31 Eastfield Drive, West Bradford, BB7 7TQ

Supporting Bat Information

Response document to Emily Pickups email, dated 26th November 2024 @ 12:08.

Drawing Number
 PL-EASTFIELD-06

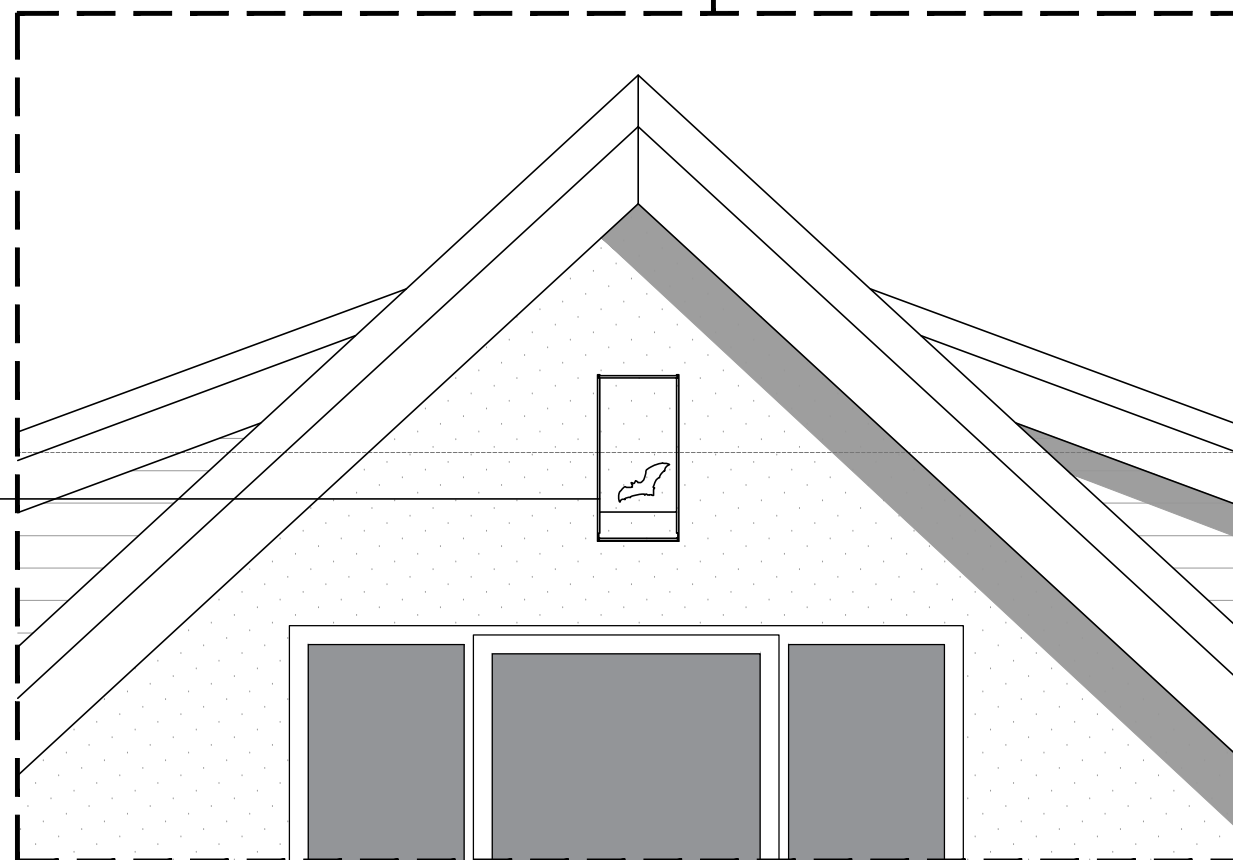
Countryside Officer comment: Notwithstanding the submitted details, no development, including any site preparation, demolition, scrub/hedgerow clearance or tree works/removal shall commence or be undertaken on site until details of the provisions to be made for building dependent species of conservation concern, artificial bat roosting sites have been submitted to, and approved in writing by the Local Planning Authority. For the avoidance of doubt the details shall identify the nature and type of the nesting boxes/artificial roosting sites and the locations(s) or wall and roof elevations into which the above provisions shall be incorporated.

Countryside Officer comment: The details shall be submitted on a building dependent bat species plan and include details of the actual wall and roof elevations into which the above provisions shall be incorporated that has a minimum of 5 hours morning sun for bats.

Applicant response: We are in full agreement **not** to start any works until full approval has been given. We are proposing to include **two nesting boxes / artificial roosting sites** for potential bat roosting, located at the front and rear of the property, permanently fixed within the brickwork. By locating the nesting boxes into the brickwork, this ensures permanent and a safe solution, providing an undisturbed place to nest. We did consider placing nesting boxes within the new dormers that will be erected, however, the dormers will require yearly treatment (maintenance), have no brick feature and aren't likely to be a permanent fixture without periodic replacement. We have taken guidance from a Bat Consultant, company E3P helping us form this response.

PL-EASTFIELD-06 (Front Elevation)

Applicant response: We are in full agreement to this condition. Locating the two nesting boxes / artificial roosting sites at the front and rear of the property will capture day light conditions, to the requirement of a minimum 5 hours. The location will be high within the brickwork, out of human reach, and within best reach out sunlight. Details below show the positioning of the sun to the property.

Bat box 1 located at the front of the property. **Bat box 2** located at the rear of the property.
